24 January, 2017

Proposed Development at: 7 Orchard Close, Cuffley, Potters Bar EN6 4QD
Application Reference: 6/2016/2728/HOUSE
Proposal: Erection of front and side extension and exterior alterations

1 Proposed Front Elevation
1:100

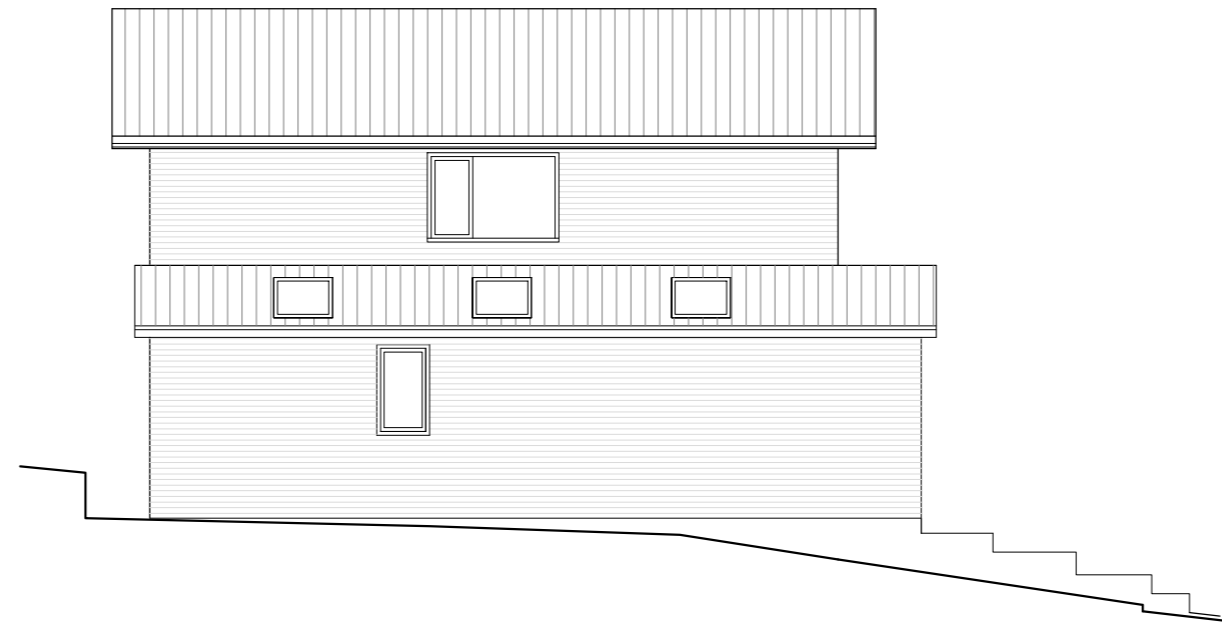
This effect would be especially prevalent given the proposed addition of a porch to the front at this side, which is detailed to extend further forward of the current building line and current house at this side. We fail to see how this addresses and solves our own concerns and objections, along with those of the Council, which gave rise to the refusal of planning permission for the last proposal.

5 Proposed Ground Floor Plan
1:100

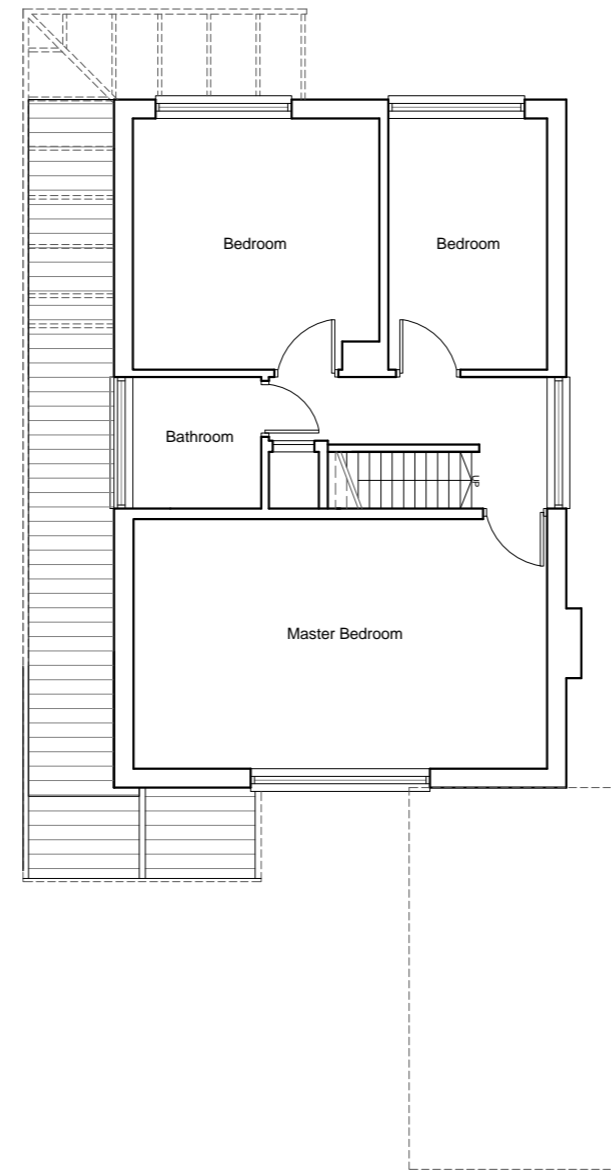
Firstly, we object to the side extension or so called 'construction under permitted development' as it is worded on the plan. We are particularly concerned about the proximity of the new flank wall to the boundary with our property. As you can see from the proposed block plan, this extension would bring the flank wall right up to the border. As a result, the foundations for this proposed side wall would appear to be sighted on our ground and would certainly undermine the foundations to our wall (which currently borders the 2 properties) and possibly the foundations to our own house.

We would also stress the need to ensure that all due care is undertaken when excavating for the footings for the new flank wall, so as to ensure that the existing boundary wall between our properties is adequately supported during the course of the planned constructions works.

Secondly, due to the lay of the land, the property at No: 7 is sited about a metre higher than our own. We are very concerned therefore that any construction to this side, even a single storey one, which comes right up on the boundary line between our 2 properties would therefore effectively increase the height of the flank wall by a metre and close our house down into the corner of the culdesac.
